Submission made by Highways England pursuant to Deadline 4 of the Examination of the A30 Chiverton to Carland Cross scheme

Josh Hodder
Project Manager
A30 Chiverton to Carland Cross

Appendix A: Overview of changes made to Environmental Masterplans

Drawing Title
FIGURE 7.6 - ENVIRONMENTAL MASTERPLANS SHEET 9 OF 20

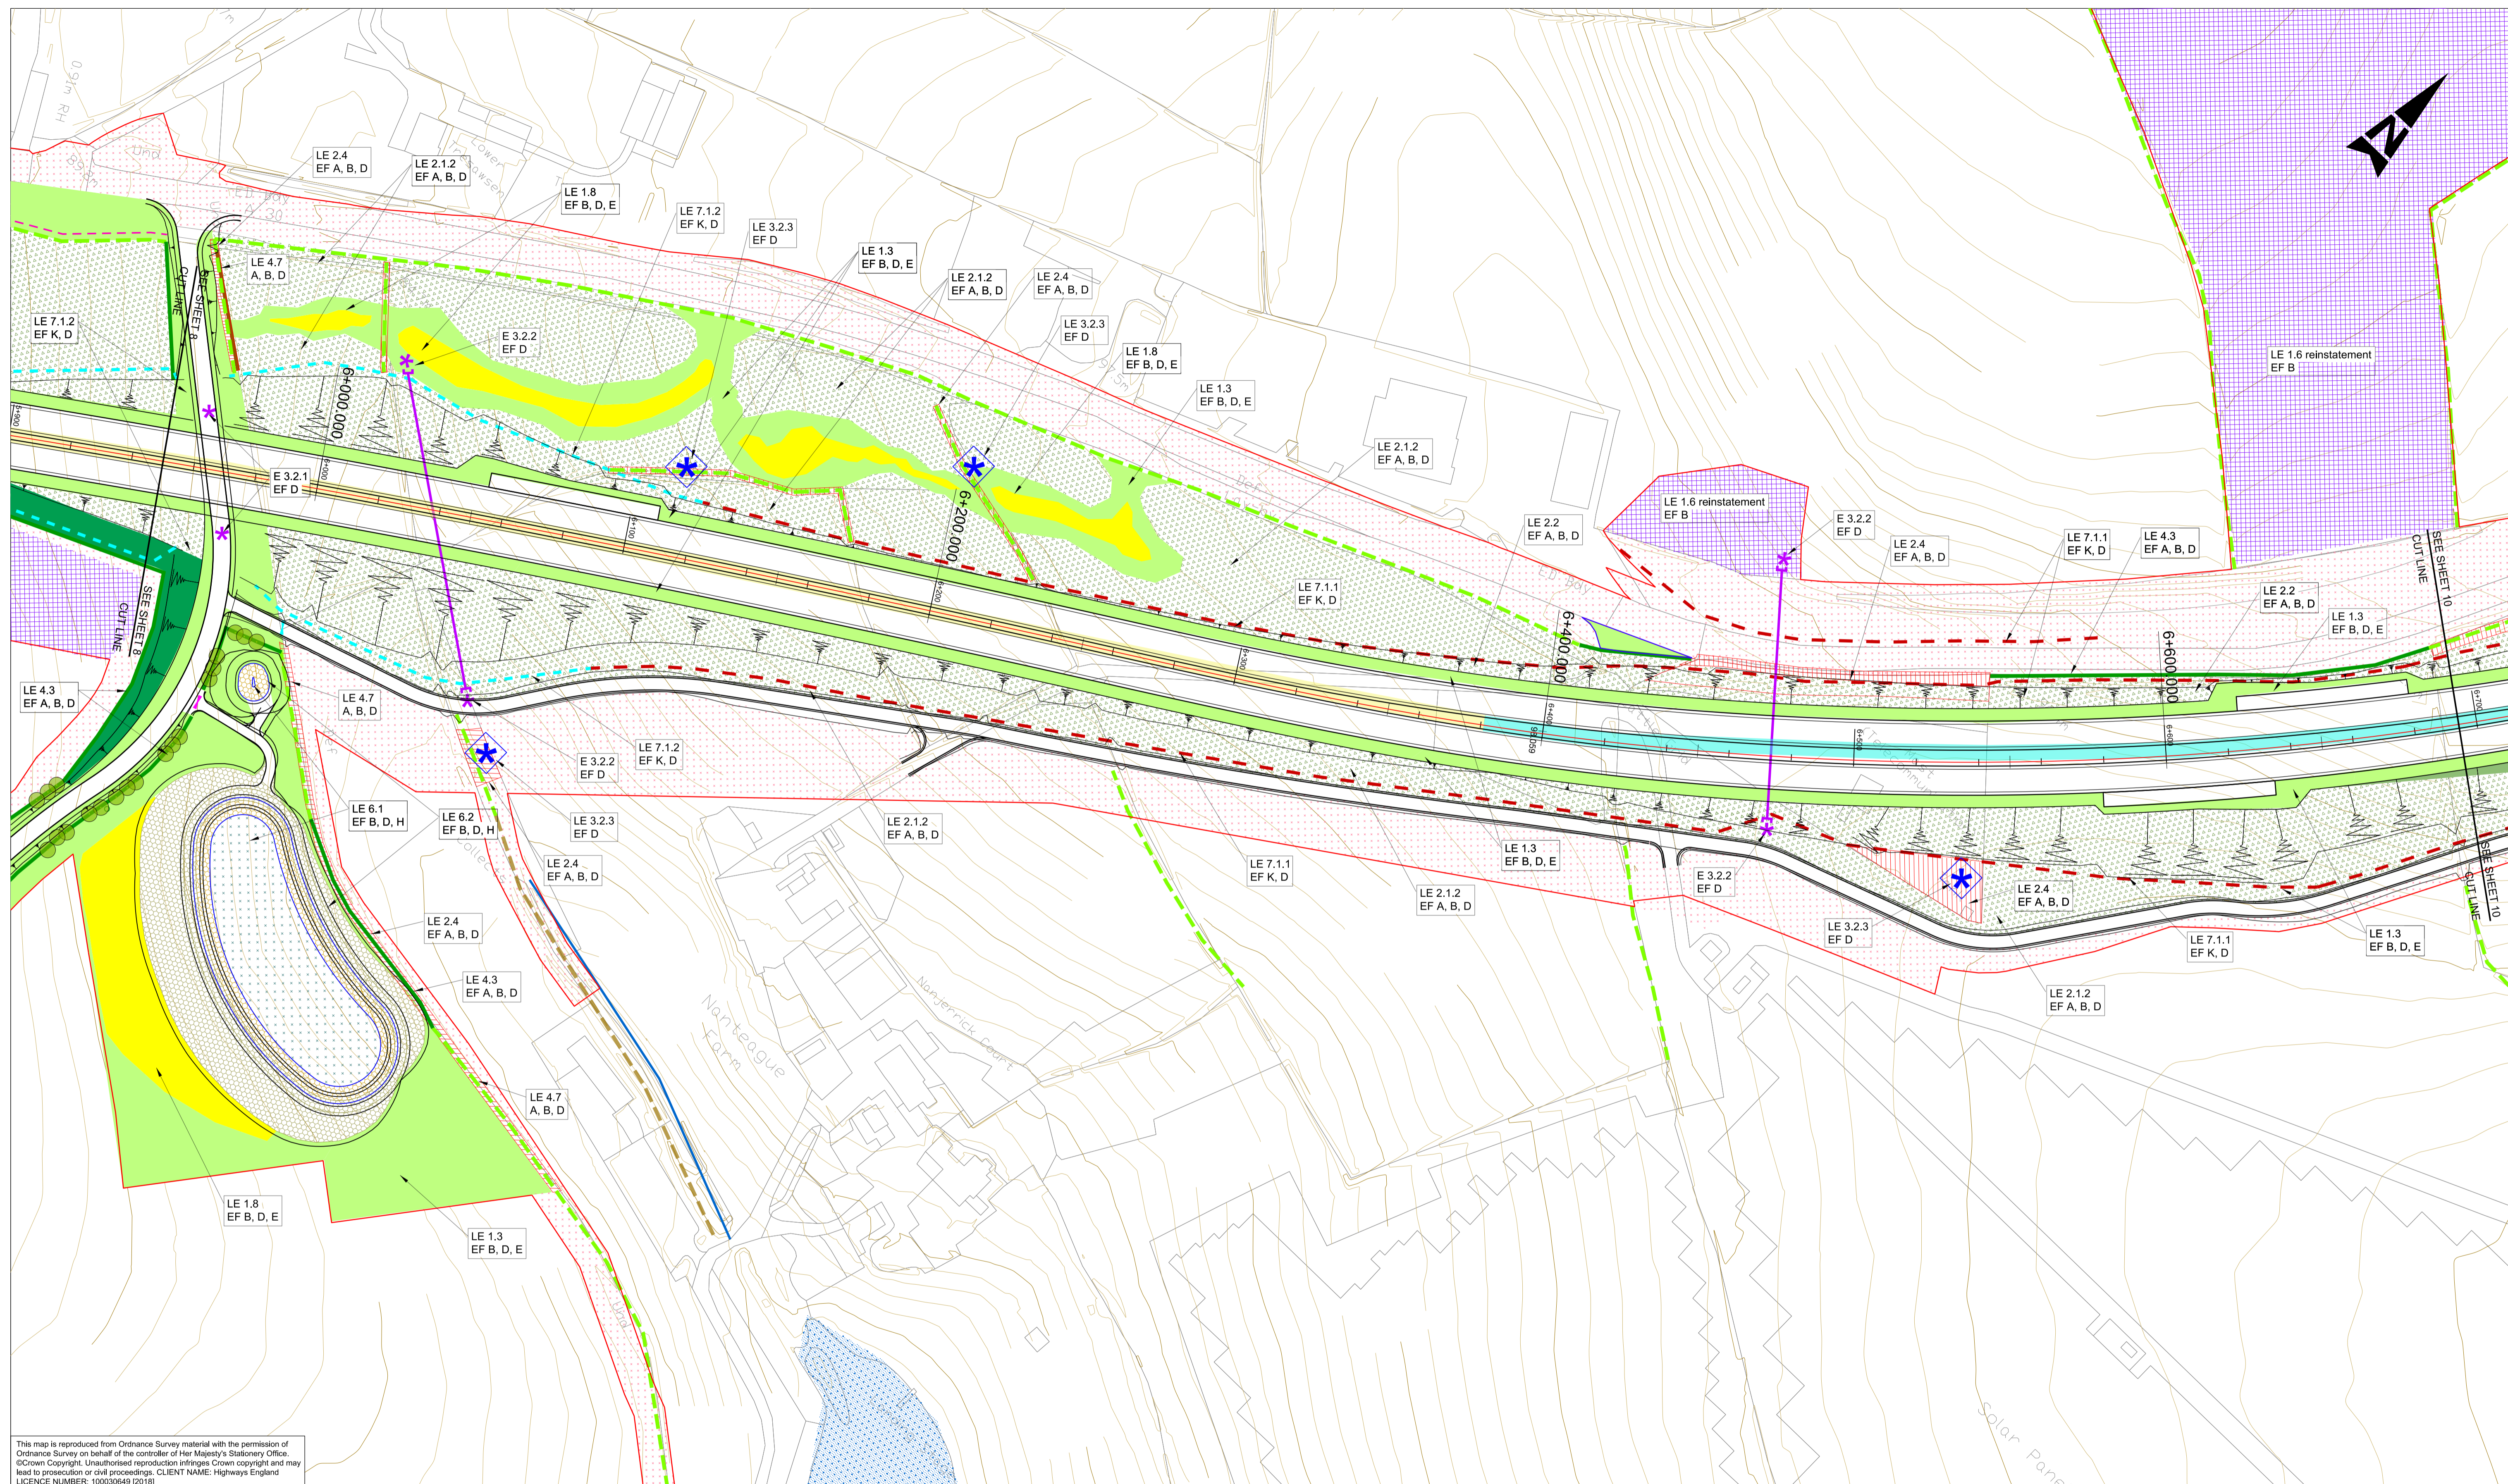
Relevant Plan	Explanation of change(s) made
Environmental Masterplans (Document Reference 6.3 Figure 7.6(A))	
Sheets 1-20	Changes to layer display and seeding in maintenance laybys along the scheme
Sheet 9	Area for replacement Communications mast identified within woodland area to the south of Ch 6,550.
Sheet 15	Amendment to the proposed lane side planting opposite Pennycomequick. 5-metre-wide woodland strip to the east of the lane omitted and a planted Cornish hedge proposed in keeping with the existing condition.
Sheet 18	Long vehicle turning arrangement added at the windfarm access to the north of the Carland Cross junction. Planting amended to accommodate a seeded hardstanding (grasscrete or similar) north of chainage 13,200 to 13,350
